Our Ref: M/25/26/NMA

**Section 96A of the Town & Country Planning Act 1990 (as amended)
Town and Country Planning (Development Management Procedure) (England) Order 2015
(as amended) - Article 10**

Non material amendment following the grant of M/60/25/HH relating to proposed Velux on south elevation.

16 Sea Way Middleton-on-sea PO22 7SA

Proposed South Elevation

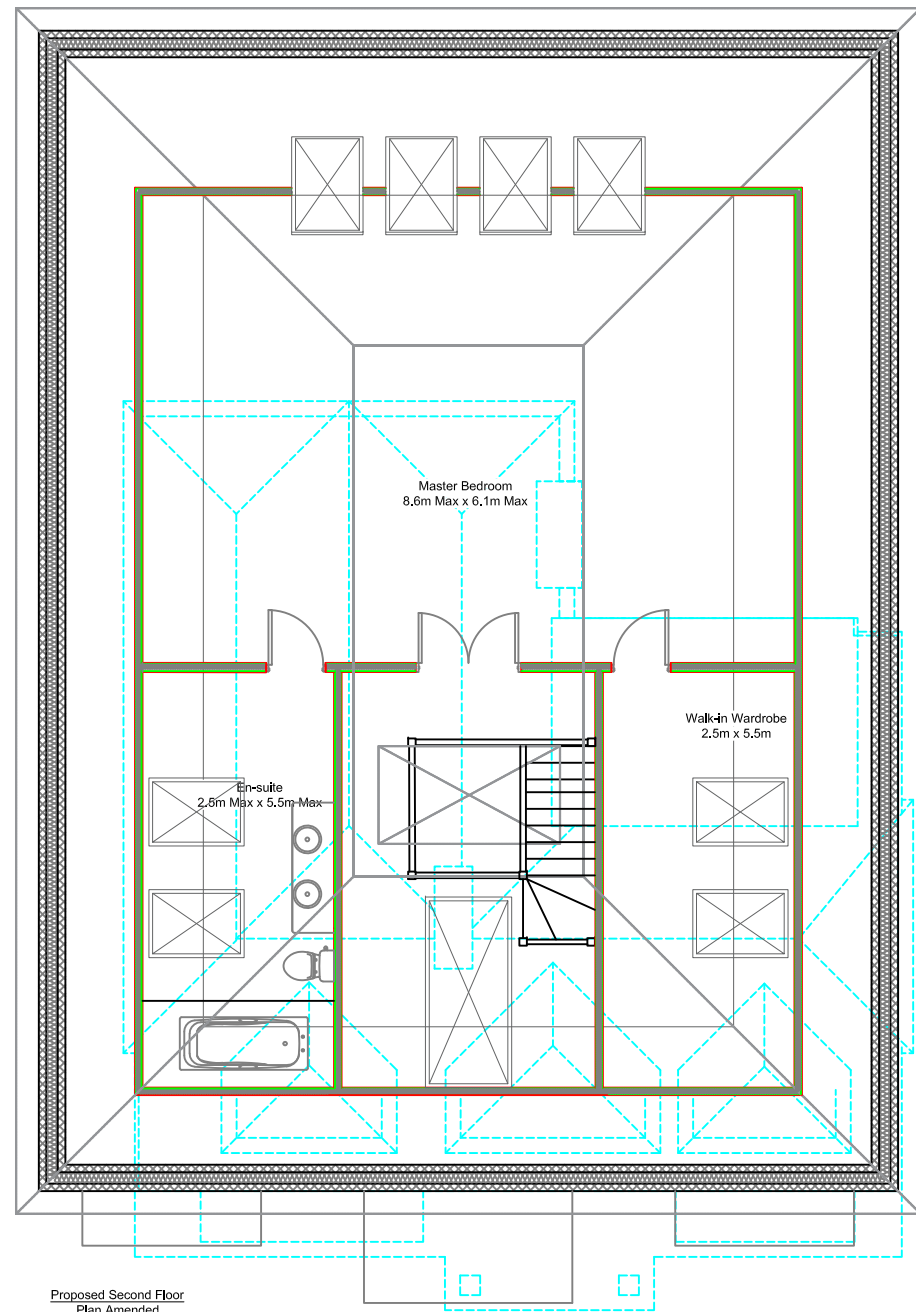
The proposal seeks to install a single Velux window on the front (southern) roof slope of property. The window is of similar appearance of previously approved rooflights on the side and rear elevations and would continue to deliver the original design of the development. The changes are therefore considered to be minor in nature and can be determined as an NMA under section 96A of the Town and Country Planning Act 1990.

From the information submitted I am able to take the alterations as a Minor Amendment to M/60/25/HH. The new plans Existing and Proposed Elevation Plans (December 2025) and
